The Member-Secretary,  
Madras Metropolitan  
Development Authority,  
No.8, Gandhi Irwin Road,  
Egmore, Madras-600 008.

Lr.No. **02/6980/90.**

Sub: MMDA - Planning Permission - proposed

**construction of Ice Factory in Ground Floor  
Level and Office in Ist and II Floor at  
S.No.27/3 of Maduravoyal Village - Remittance  
of Development charge - Requested - Regarding.**

SITE PLAN
SCALE 1:200

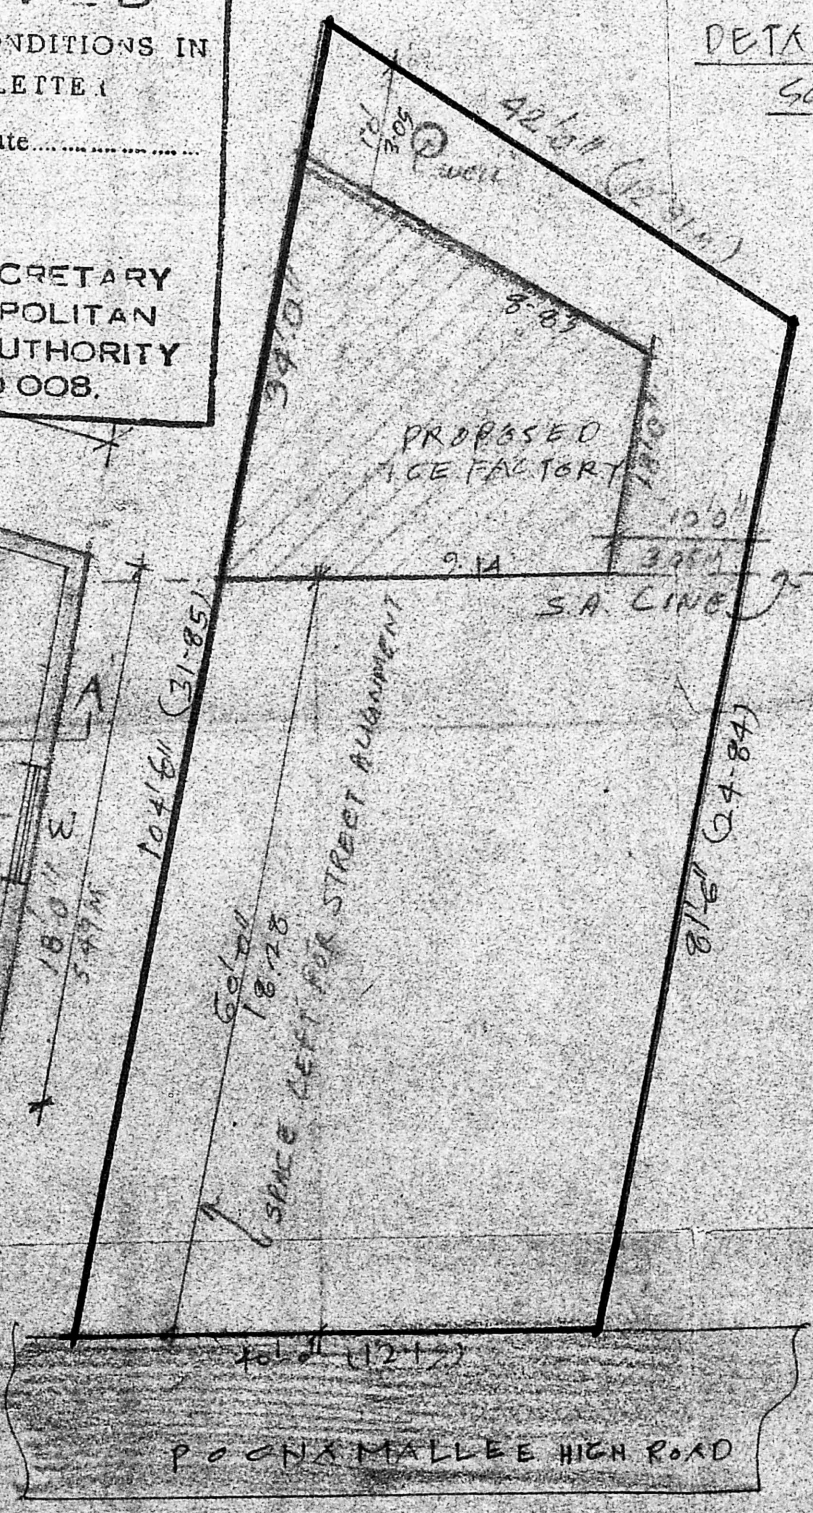
by a Demand Draft of any nationalised bank in Madras, drawn in favour of the Member-Secretary, MMDA or may be remitted in cash at the cash counter of the MMDA within ten days on receipt of this letter. You are also requested to furnish an undertaking deed and Indemnity and Affidavit Bond duly notorised and revised plan correcting the Typical Floor dimension as 34'.0" and marking S.A. line and mentioning as space left for future Road widening in the site plan.
